Response to Submissions Report
New Primary School at Googong
SSD-10326042

On behalf of
NSW Department of Education
September 2021

This Response to Submissions (RtS) report has been prepared by Mecone NSW Pty Limited on behalf of the NSW Department of Education (DoE) to support the proposed primary school in Googong, NSW (SSD-10326042).

SCALE 1 : 250 @ A1			
21 SEPTEMBER 2021			
PROJECT	PHASE	SERIES NUMBER	REVISION
GOOG - SSDA - 021			F

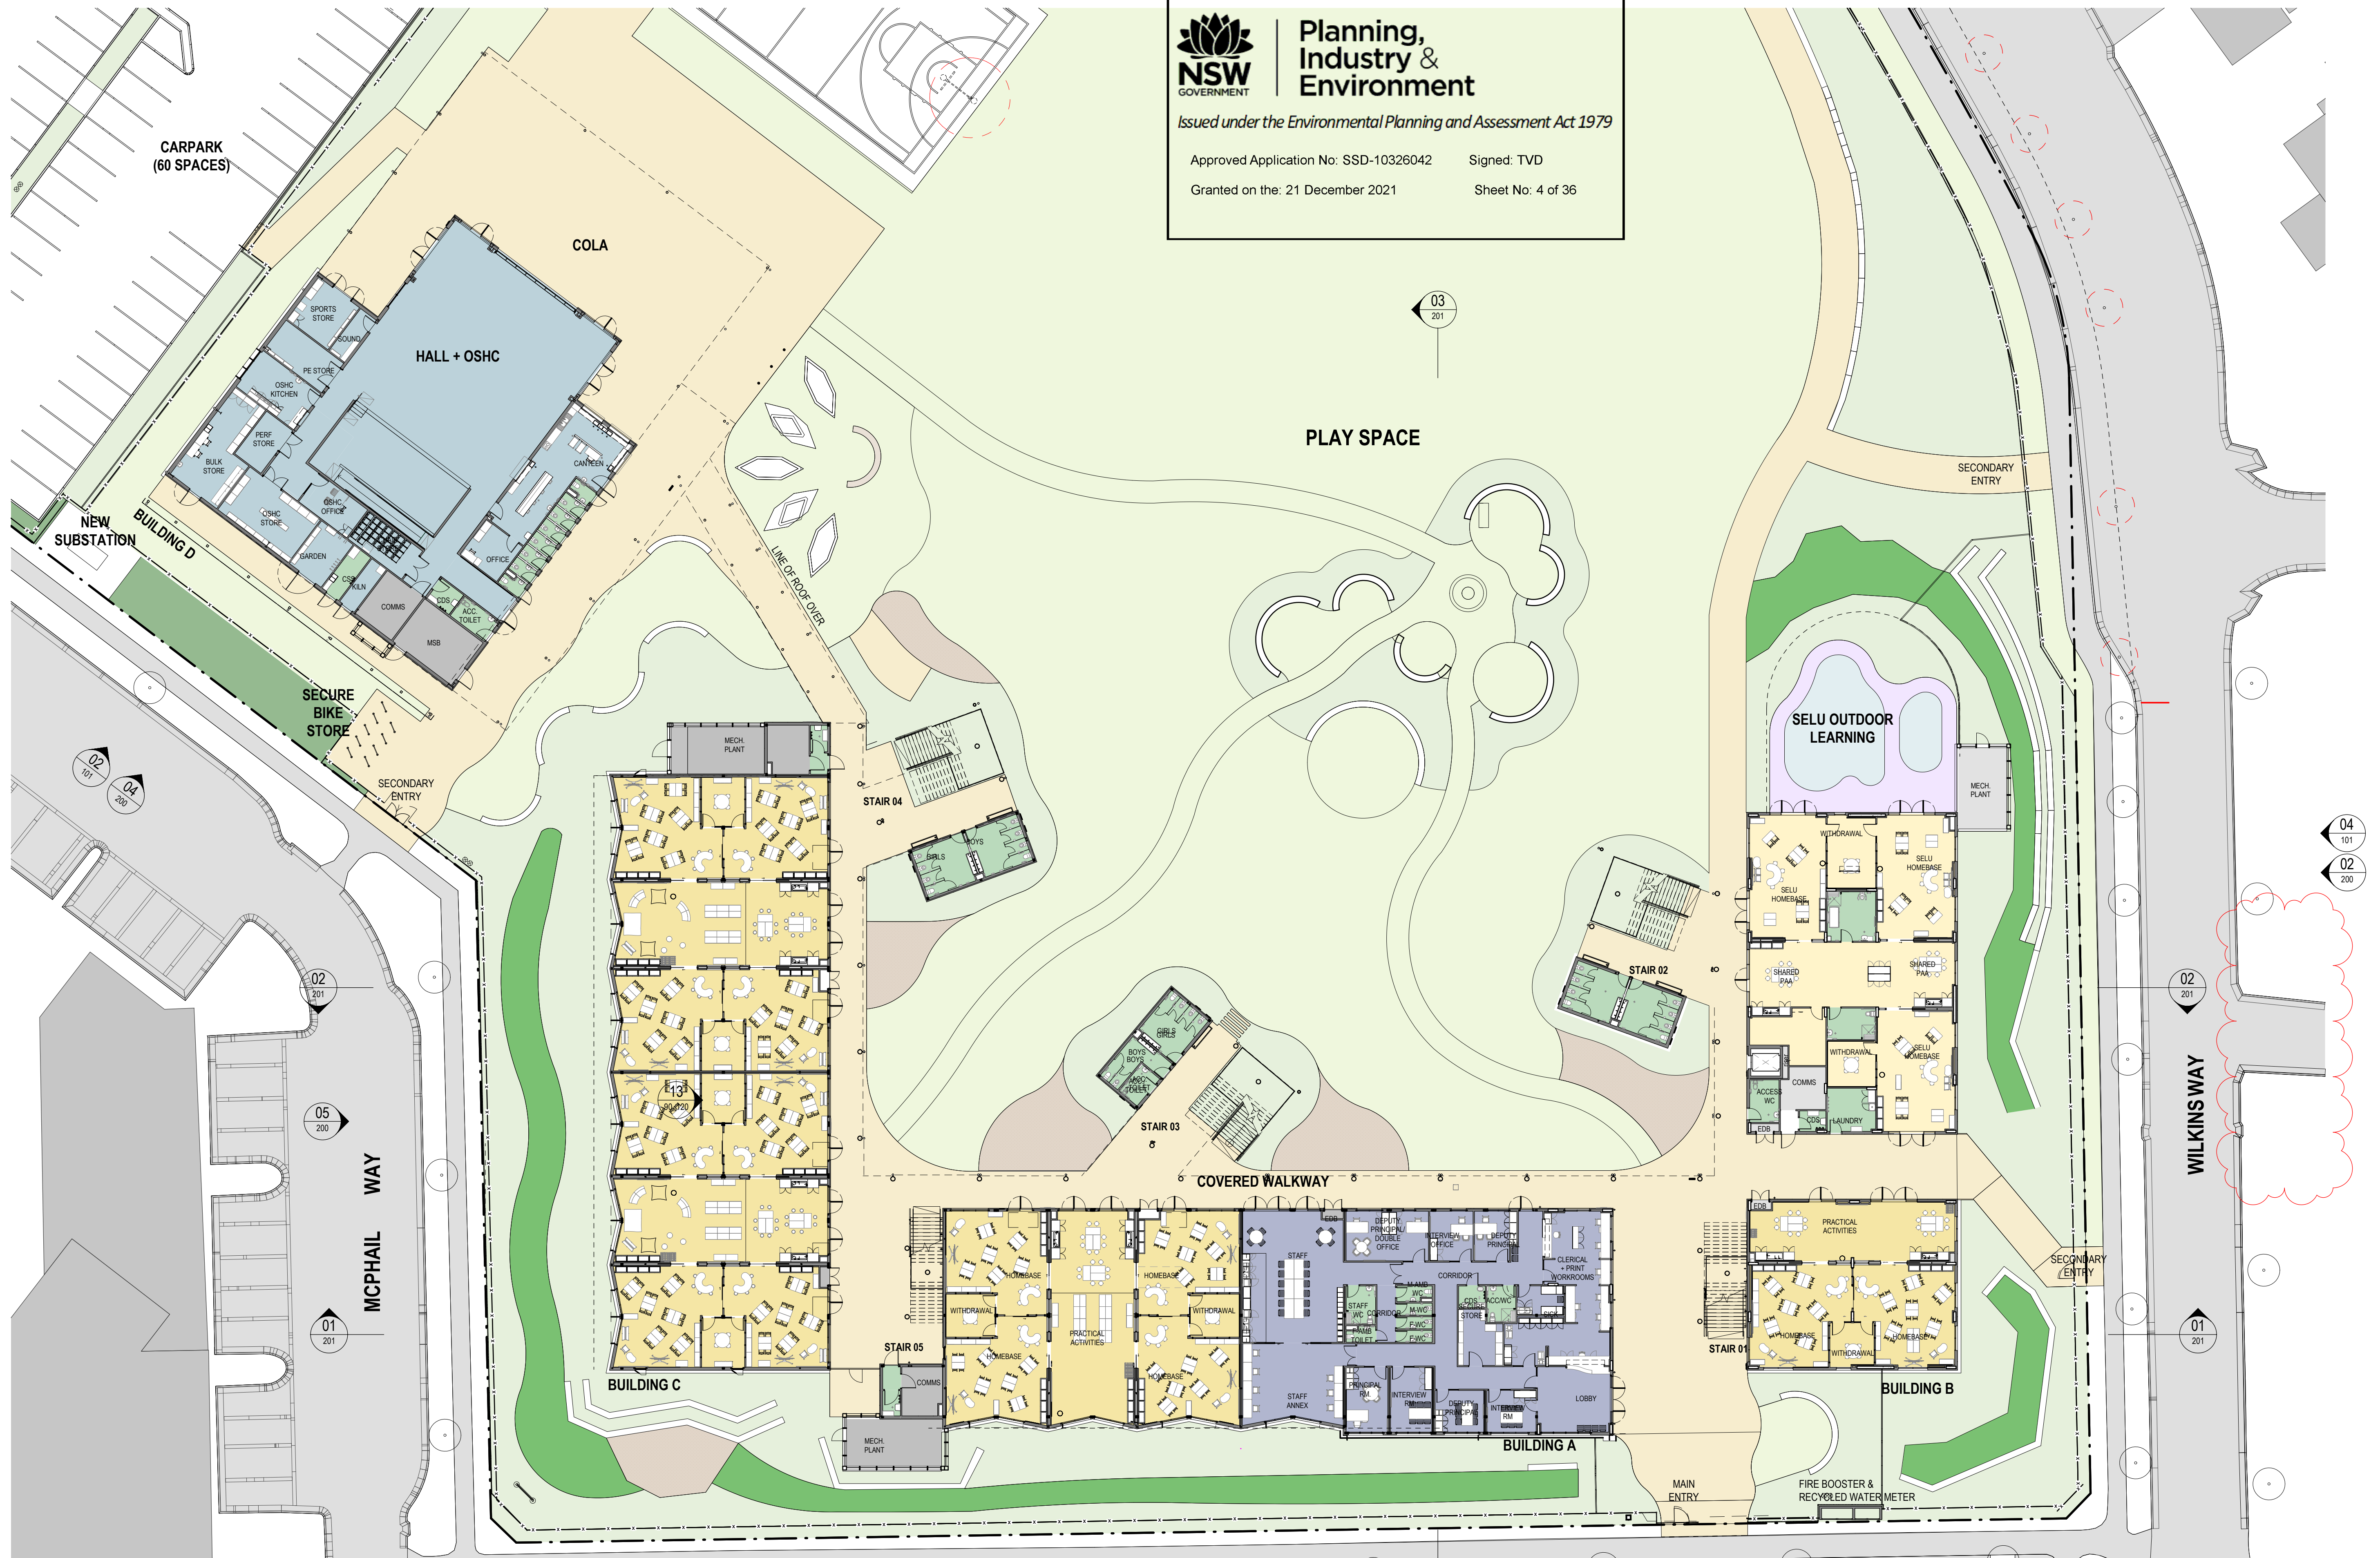
In its submission, Council advised it did not support the location of the kiss-and-ride along Aprasia Avenue primarily due to issues associated with the narrow width of the road. Council recommended that the kiss-and-ride be relocated to along Wilkins Way (first preference) or within the site (secondary preference). The project team met with Council officers twice following receipt of Council's submission to discuss this matter along with other issues.

In its submission Council advised it did not support the number of pedestrian crossings and recommended that the number of crossings be minimised.

A digital pylon sign was originally proposed at the main vehicular entry along Aprasia Avenue, facing the residential properties across the street. In its submission, Council recommended that any proposed illuminated signage should not face residential properties.

Following discussions with Council, the kiss-and-ride area has been relocated to Wilkins Way, consistent with Council's recommendation, as shown in the figure below. The relocated kiss-and-ride will require slight widening of Wilkins Way. The public domain plan at Appendix 7 of the RTS identifies the extent of the works.

In response, the two crossings at either end of the Gorman Drive frontage have been replaced with a single mid-block crossing, as illustrate in the figure below. The location of this crossing was supported by Council officers at a meeting on 9 September 2021.

- The gate has been set back to ensure the carpark is compliant with Australian Standards, allowing for a two-car queuing space.
- The waste pad has been relocated to the northwestern corner of the car park to allow for collection by an 11m front-lifting waste truck.
- The corners of the carpark car park have been “squared off” to allow for appropriate servicing maneuverability.

In response, the pylon sign has been moved to the corner of Gorman Drive and McPhail Way so that it faces the commercial development across McPhail Way, as illustrated in the figure below. The design of the signage remains unchanged.
